Engineers Comments Regarding Surface Water Drainage

Application Reference:	Y/48/25/PL	Reviewer Reference:	ADC/KW and SB
Planning Officer:	Harry Chalk	Date of Review:	11/11/2025
Site Name:	Church Farm House Church Road Yapton BN18 0EP		
Application Description:	Removal of tennis court and construction of 1 No. self-build single storey energy efficient dwelling. This application is a Departure from the Development Plan, may affect the setting of listed buildings, affects the character and appearance of the Church Lane, Yapton Conservation Area and is in CIL Zone 3 and is CIL Liable as a new dwelling.		
Assessment Number:	1 of 1

Appendix A – Soakaway Test Location Plan

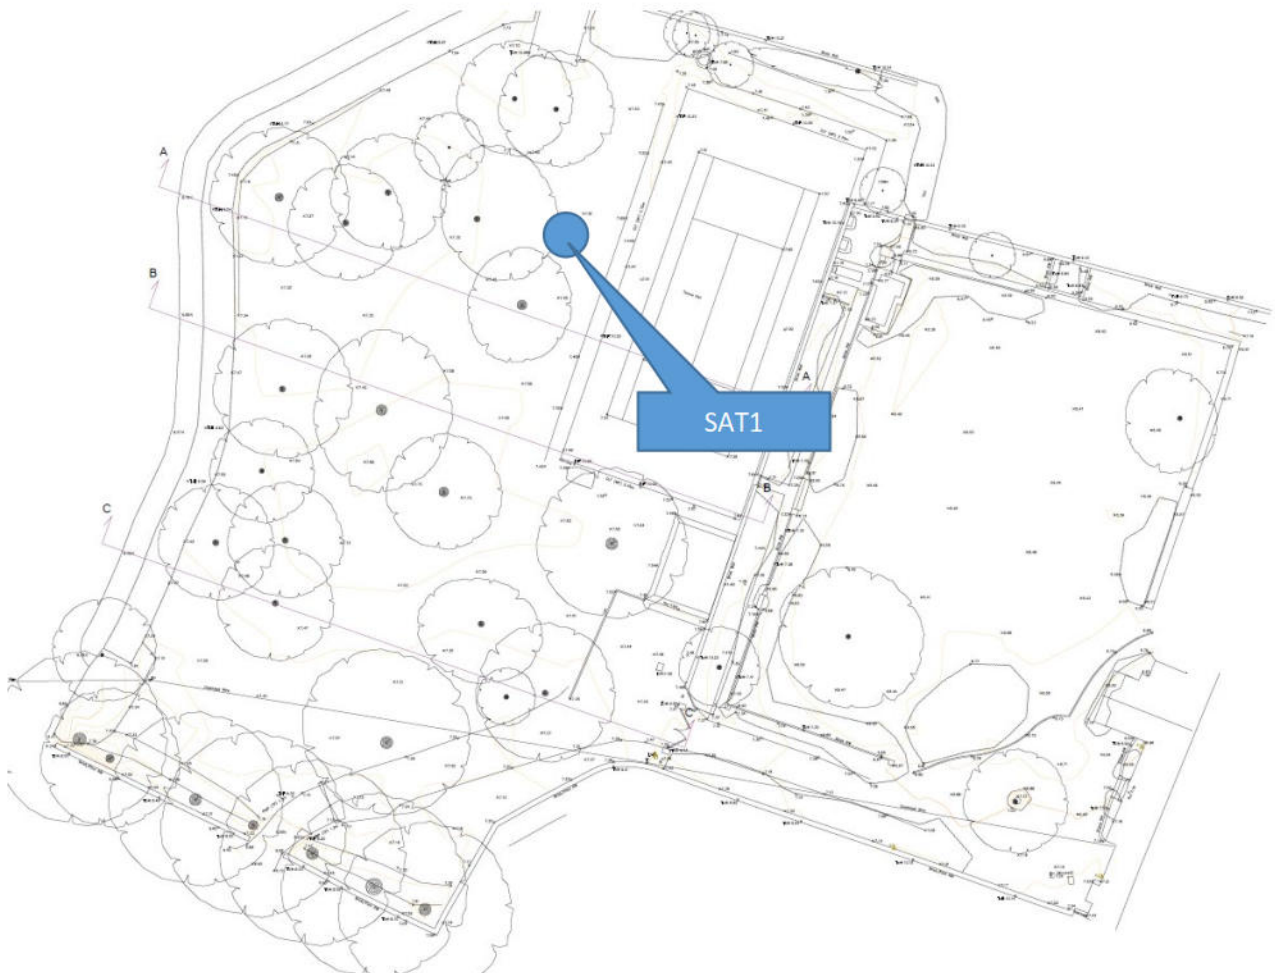
- 1.4. The FSWDR includes infiltration testing completed on 26 October 2025. Records of the strata in the trial pits were not submitted. The testing was completed outside of the winter period and therefore does not accord with BRE DG 365 and may not be used for detailed design purposes. The testing provides some comfort that infiltration is likely to be viable. However, the space needed for storage may be greater than that designed due to slower infiltration potential in worse case winter conditions.

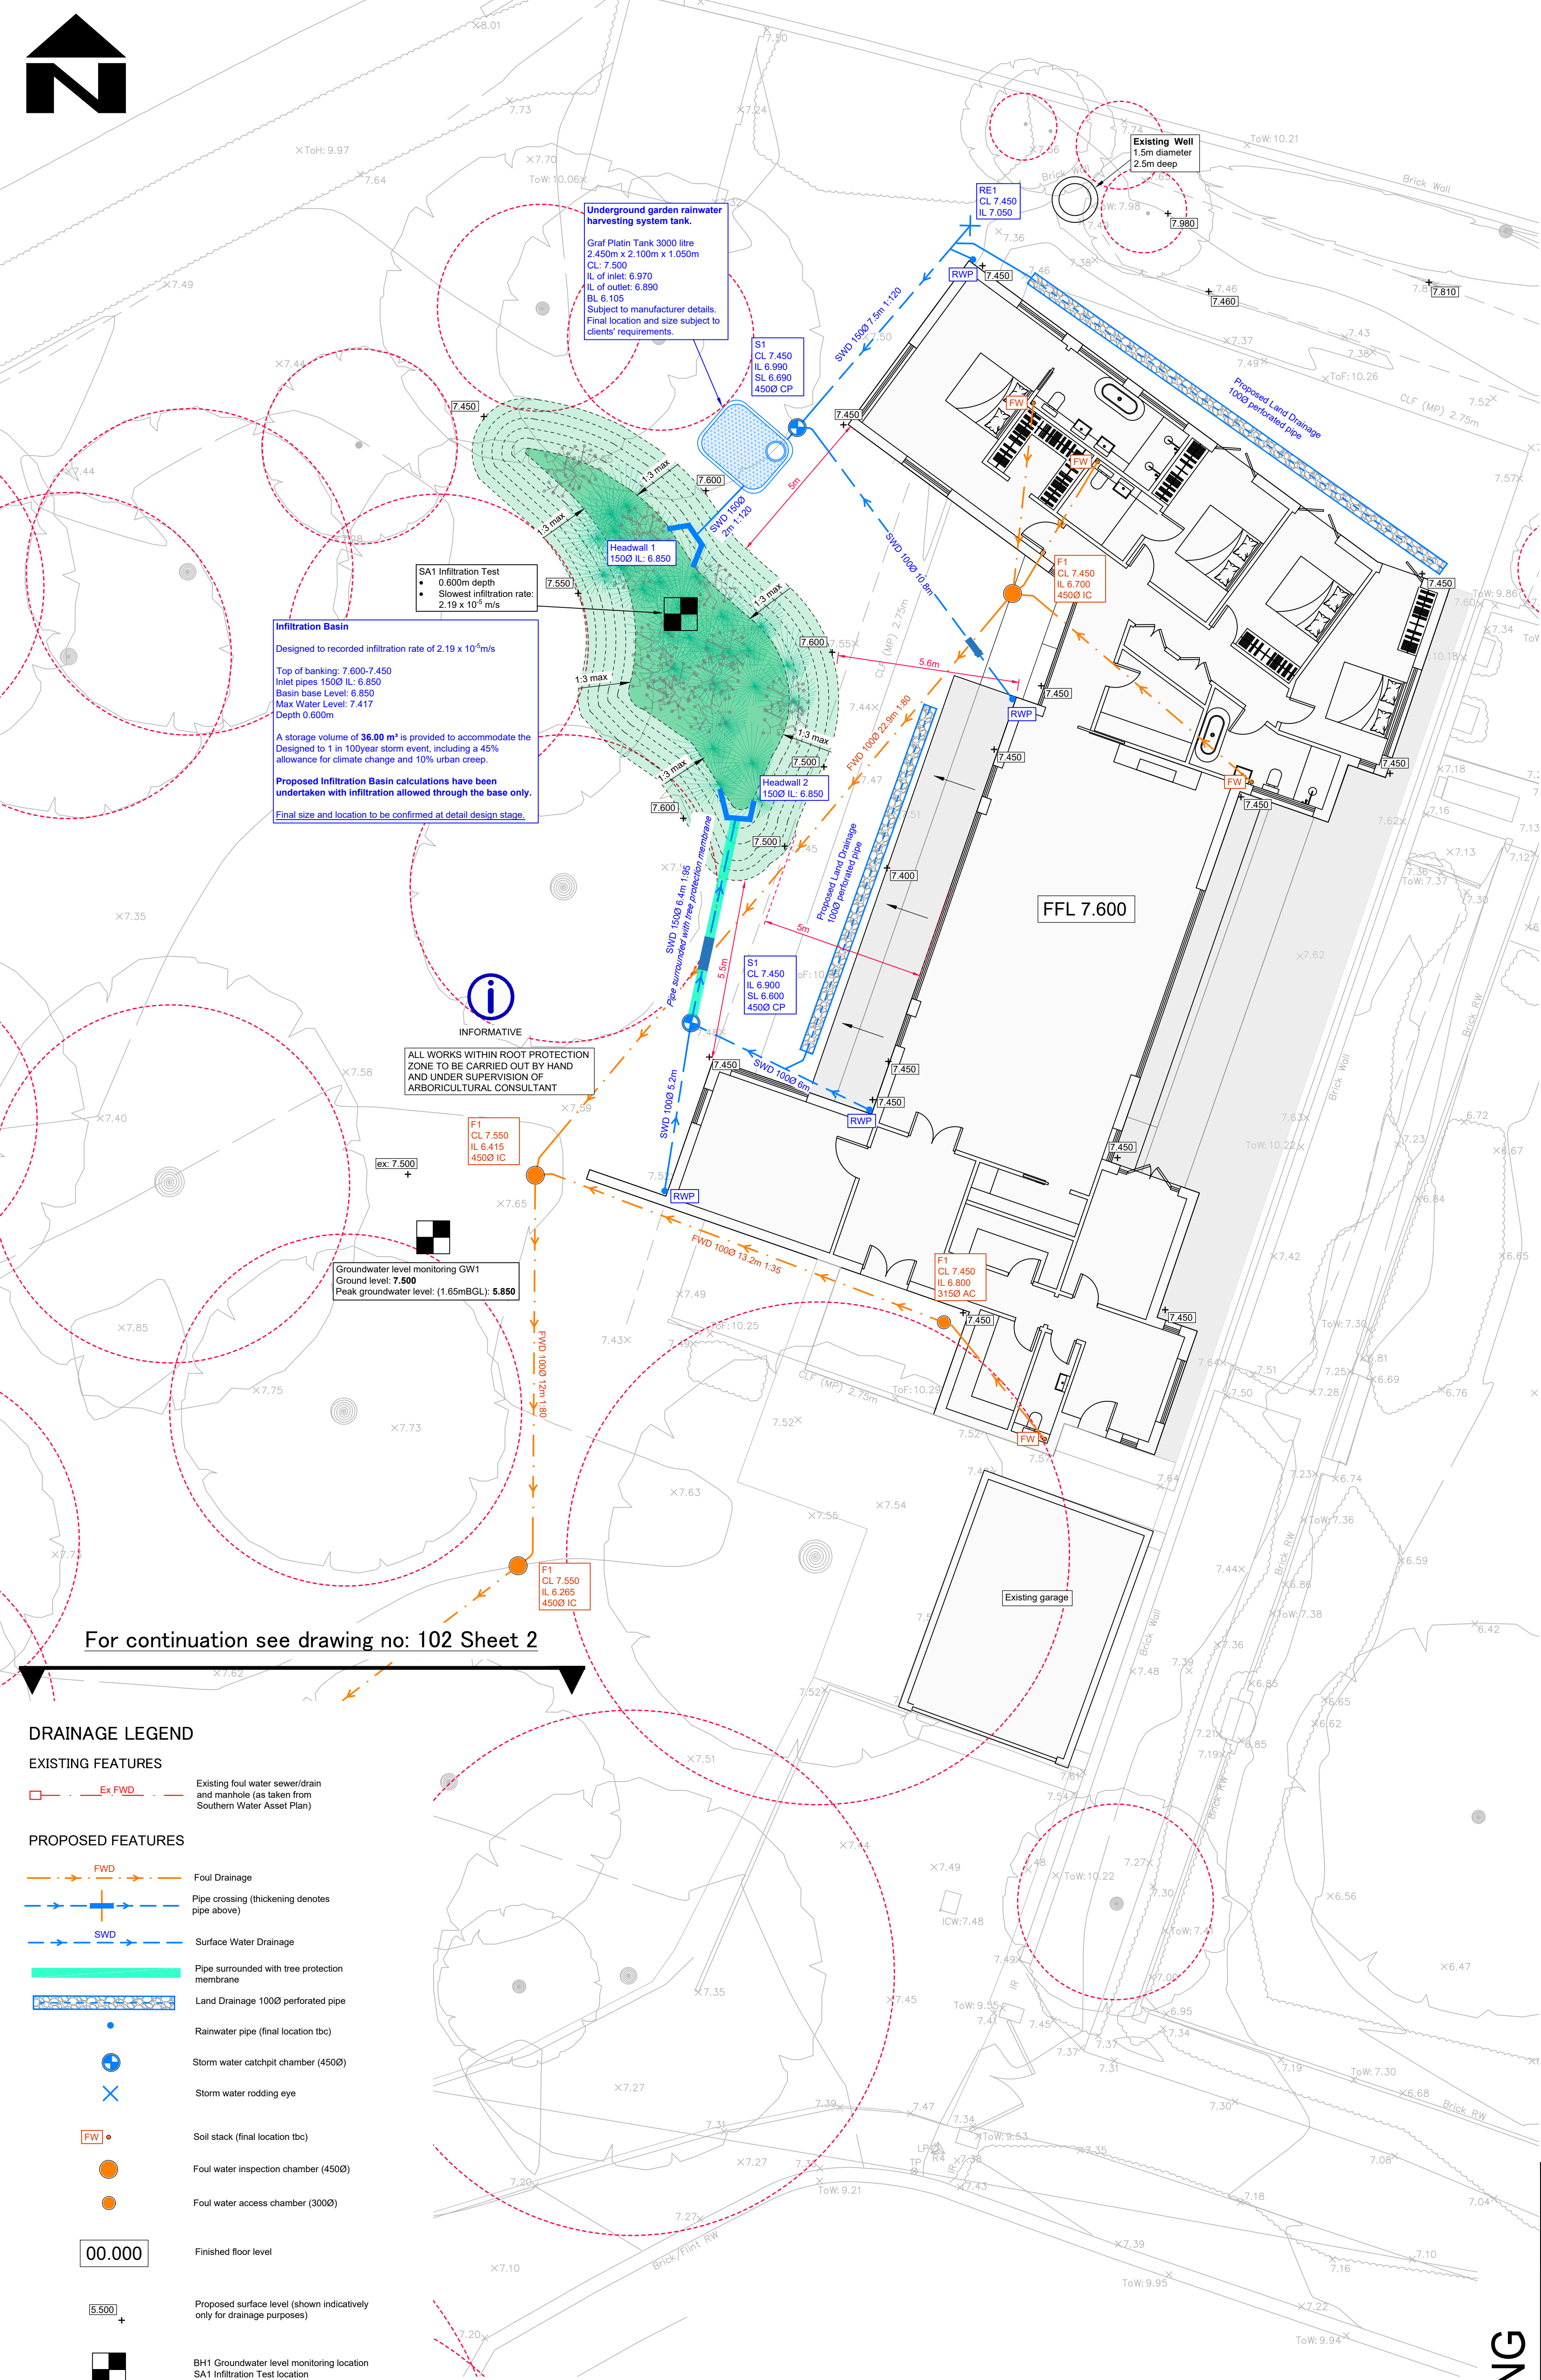
- 3.1. The FSWDR includes drainage plans and modelling. The simulation for the 1% AEP + 45% event has a maximum water level of 7.468mAOD. This is higher than the bank at the north east extent of the infiltration basin (7.45mAOD) and the cover levels of both inspection chambers and the rodding eye. The model demonstrates that the system may flood on the 1% AEP + 45% event. This may be permissible, however, such planned flooding must be demonstrated to remain on site and not flood the property. The submission does not demonstrate that.

- 3.2. It is acknowledged that the modelling does not include the upstream network and that additional storage will be provided by the pipework and inspection chambers. However, it is unknown if this storage is sufficient to contain all surface water within the designed system.

- 3.3. The assessment is further complicated by other elements of the standard which demand design adjustments to ensure that the SuDS design is compliant and not increasing flood risk. As submitted, there is insufficient freeboard between the maximum water level in the critical 1% AEP + 45% event and the finished floor levels (FFL). It is expected that a minimum (reduced) freeboard of 300mm is maintained between FFL and the maximum flood depth or water level in the basin. At present FFL are set to 7.6mAOD, allowing for only 132mm freeboard. The minimum freeboard may be achieved by raising FFL or by having a shallower maximum water depth, alternatively the freeboard could be potentially contained within the basin itself. The submitted design represents an unacceptable risk in this regard.

- 3.4. The designer has included two land drains, north and west of the proposed dwelling. These are designed to capture surface water flowing towards the proposed dwelling. This design feature is apparently included due to the need for the FFL to closely align with the existing tennis court level. Where there is a need for surface water to be intercepted this should be accounted for in the design. It may be the surface water is diverted around the building without contributing to the SuDS scheme. This may be appropriate if the natural catchments are followed.

- 3.5. Alternatively, land drainage features can contribute to the SuDS design (as drawn). However, if they positively connect to the system then the contributing surface water volume from these features should be accounted for. This involves analysis of the contributing catchment which has not been submitted. The submitted SuDS allows an unquantified volume of surface water to be drained into the infiltration basin. This surface water volume will consume storage which is set aside for the rainwater that falls on the new contributing area. This means that there is an increased likelihood that the basin will flood. The design must be altered to account for this volume or to manage the land drainage in an alternative manner.

- 3.6. A factor of safety of 2 has been used in the design. As the contributing area is between 100m² and 1000m² the factor of safety is expected to be 1.5 or 3. The onus is on the designer to justify the factor of safety that is used, however, 1.5 may only be used where there can be expected to be no damage or inconvenience from flooding.

Drawn	CB		Client: CGS CIVILS LTD		
Approved	JO		Project: GROUNDWATER MONITORING WELL INSTALLATION CHURCH FARM HOUSE, YAPTON		
Date	25/10/2024		Title: INVESTIGATION LOCATION PLAN		
Scale	NTS		Project no:	NN1892	Figure no: FIGURE 1
Original	A3				Rev: 1

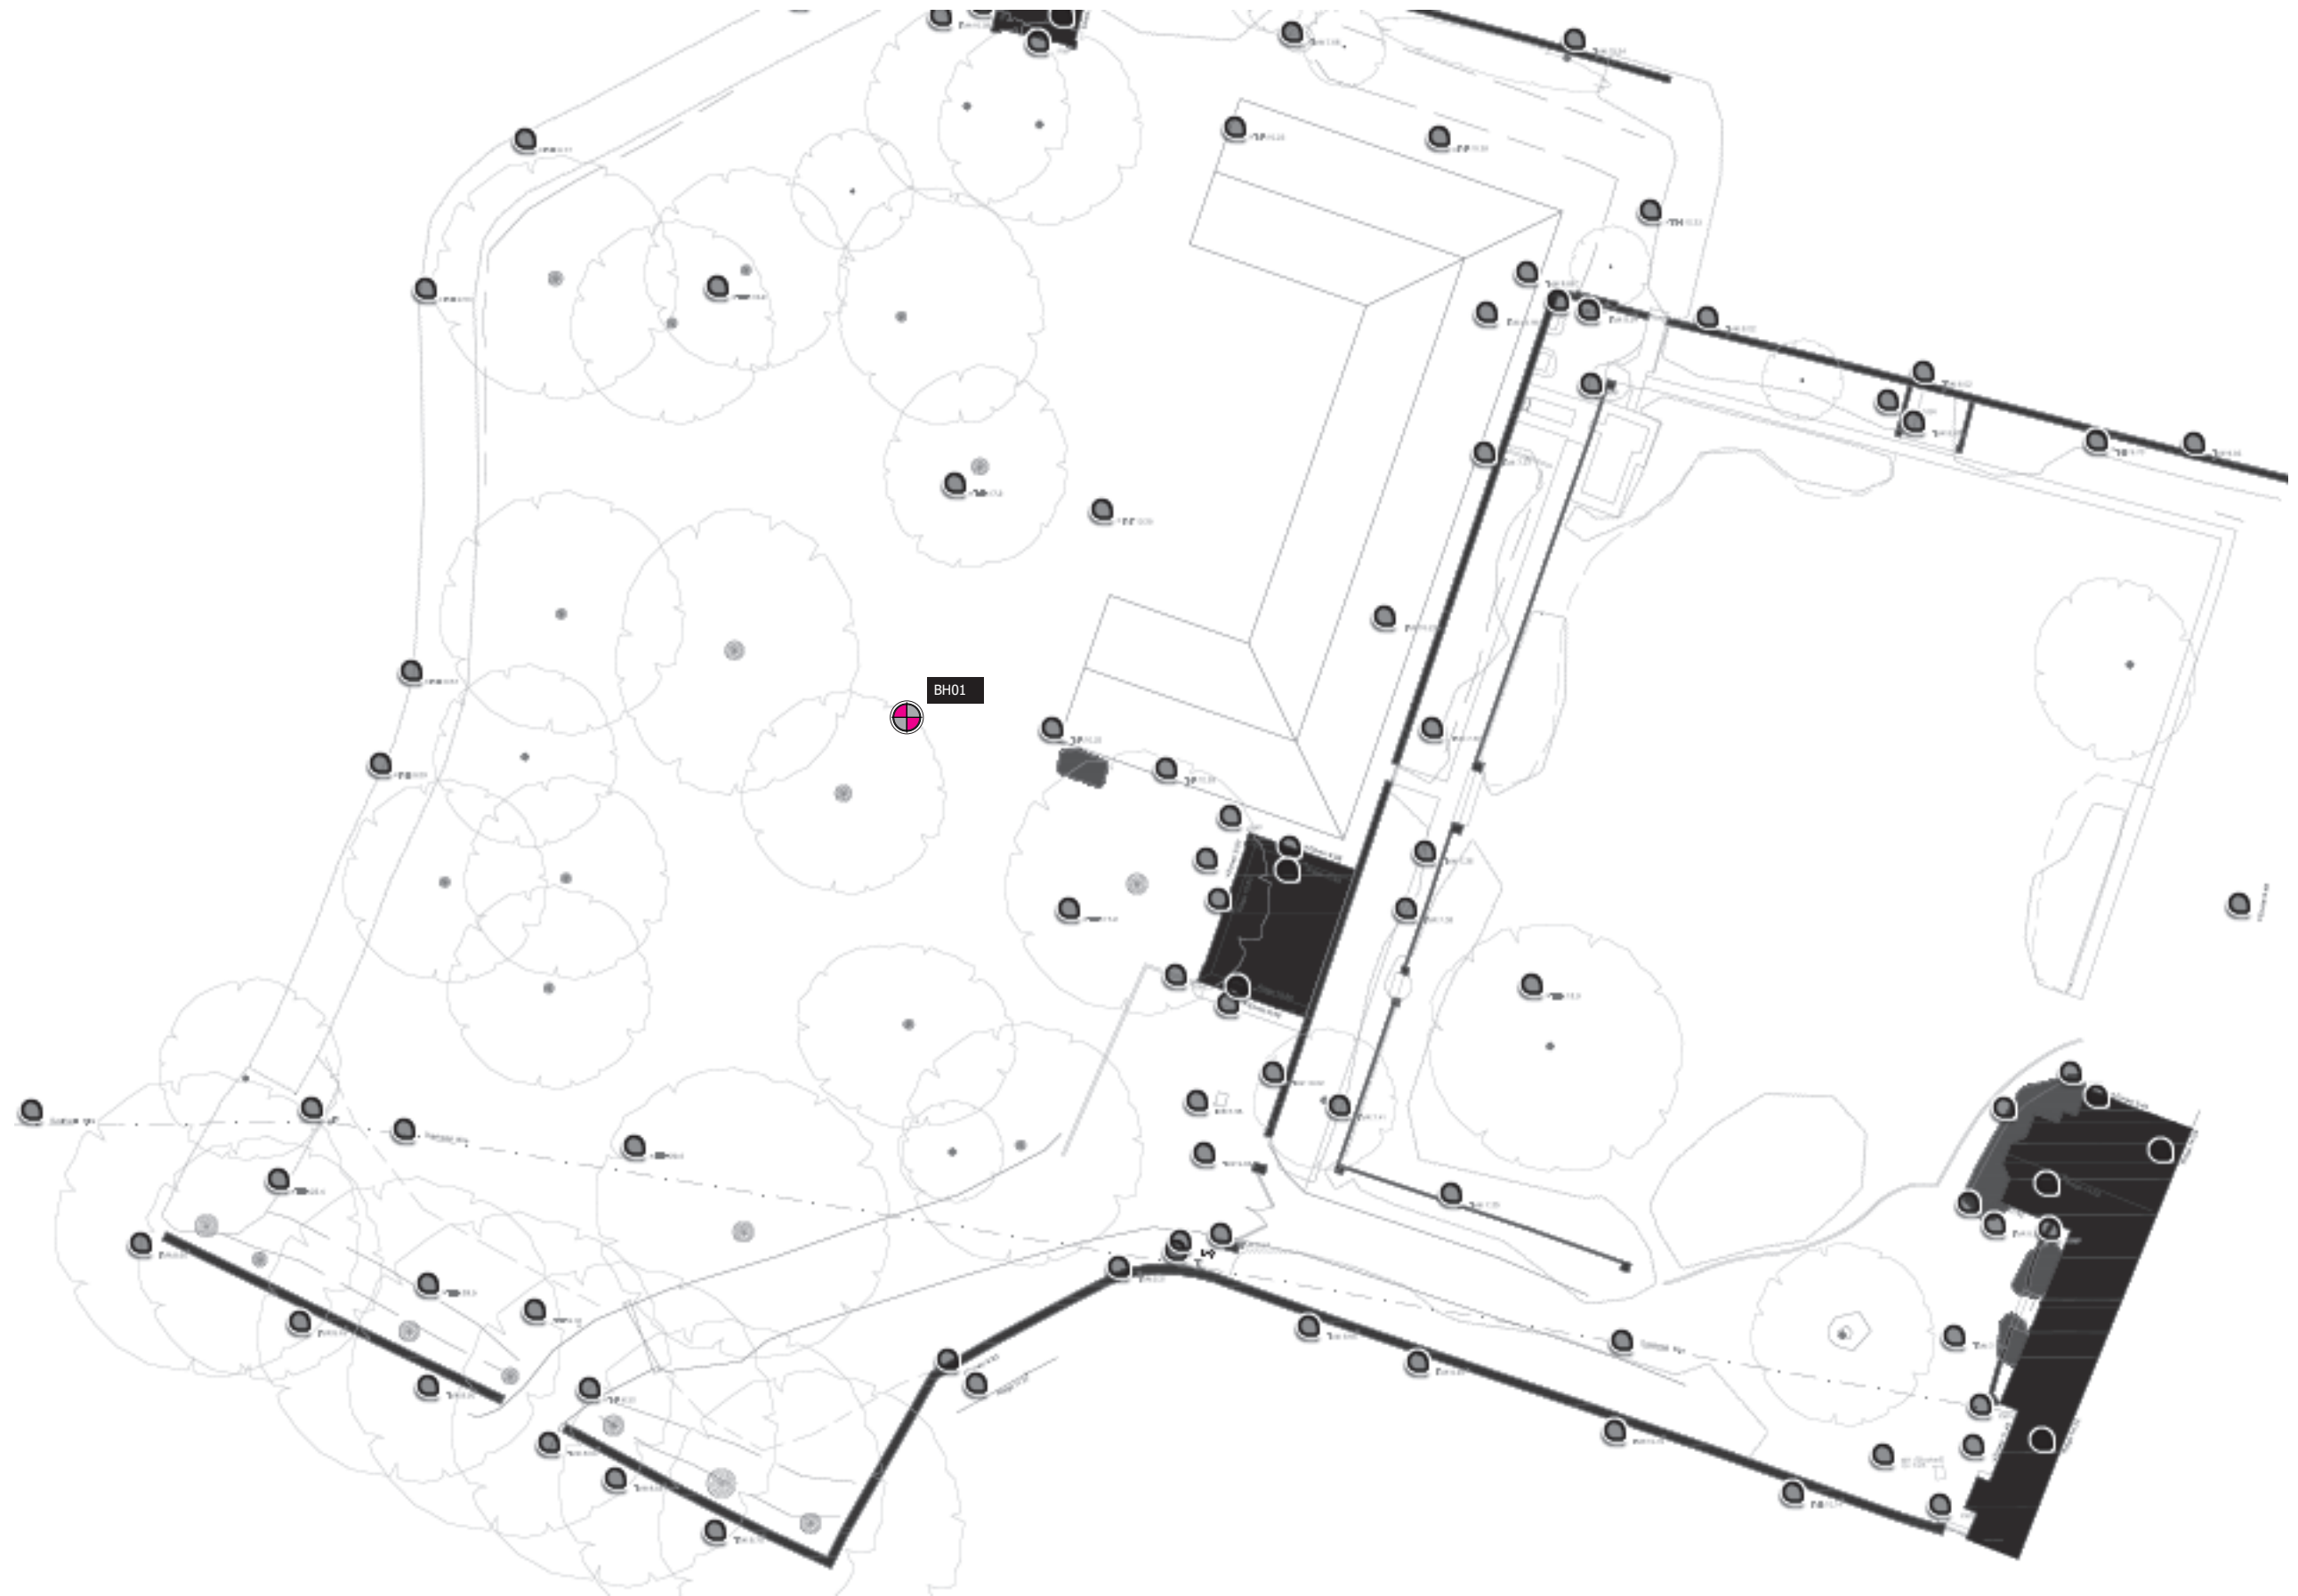
- 1.2. Winter site specific groundwater monitoring has been submitted which demonstrates that there may be potential for shallow infiltration on the site. The peak groundwater level was evidenced to be at 1.65m below ground level (bgl) on 22 November 2024. Groundwater was monitored from 25 October 2024 to 11 March 2025. This period is likely to capture the peak groundwater level, although the observations were fortnightly which may have meant a peak could be missed between observations. Due to the scale of the development the groundwater monitoring completed to date is not challenged and no further monitoring is required.

- 1.3. To allow for 1m of unsaturated ground between the base of an infiltration feature and the peak groundwater level, any infiltration feature must be set at a level higher than 9.6mAOD (0.6mbgl). It is noted that the borehole record in the groundwater monitoring report is the only record of the geological strata on the site. This shows that there was MADE GROUND to a depth of 0.8m in the borehole. This may impact the potential for infiltration on the site as infiltration should be avoided into made ground without the advice of a geotechnical expert. Such advice has not been submitted and there is no evidence to demonstrate that this borehole is an anomaly.
